The Member Secretary,
Chennai Metropolitan
Development Authority,
No.8, Gandhi Irwin Road,
CHENNAI -600 008.

Letter No. A1/8889/2000.

Dated: 30.08.2000.

Sub: CMDA - Planning Permission - Construction
of Residential Building at Plot No.20,
Madura Gangu Reddy Kuppam of Thiruninravur
village in S.No.31/5C - Development Charges
and Other Charges to be remitted - Regarding.

SITE PLAN (SCALE 1:200)

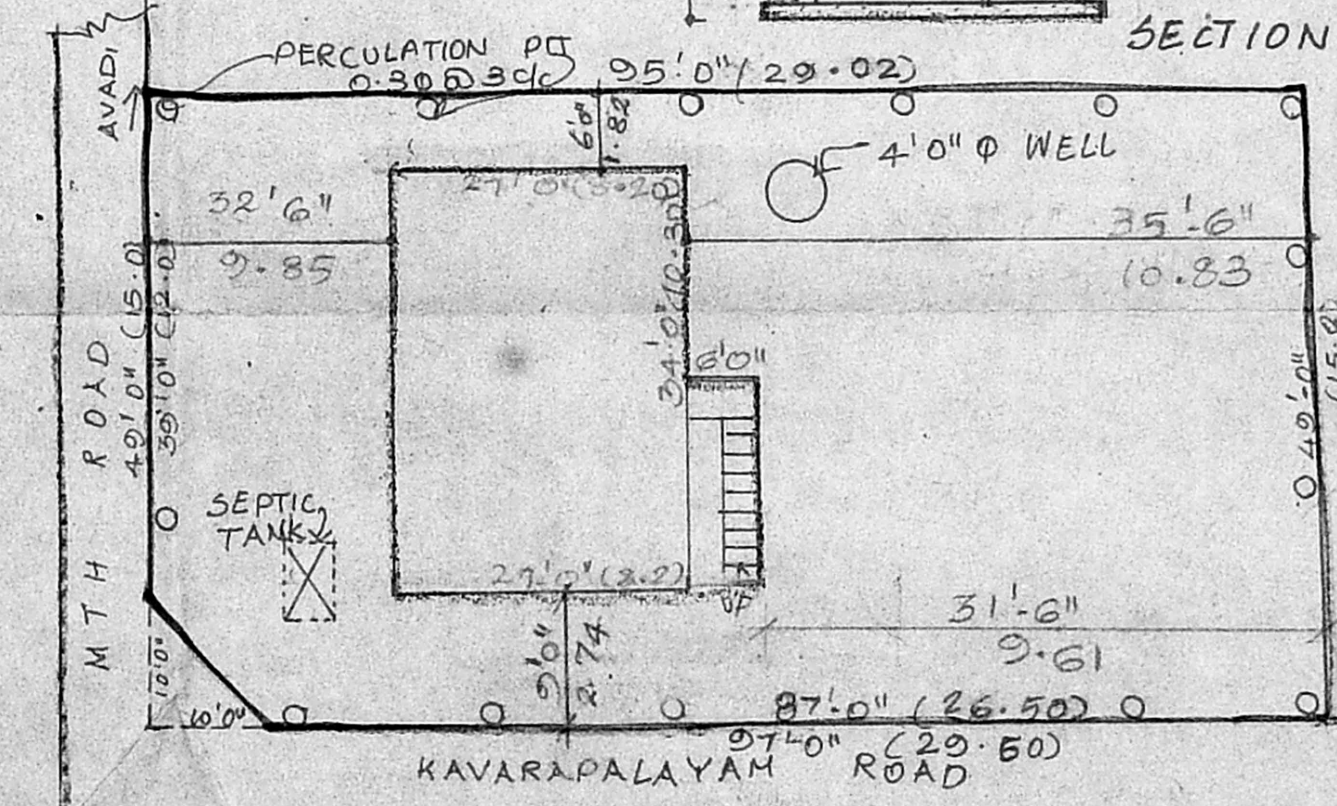
- a) Rain water conservation regulations stipulated by CMDA should be adhered to strictly.
- b) **5 copies of revised plans mentioning the S.No. in the title of the plan as per pattah and clear set back in the western side.**
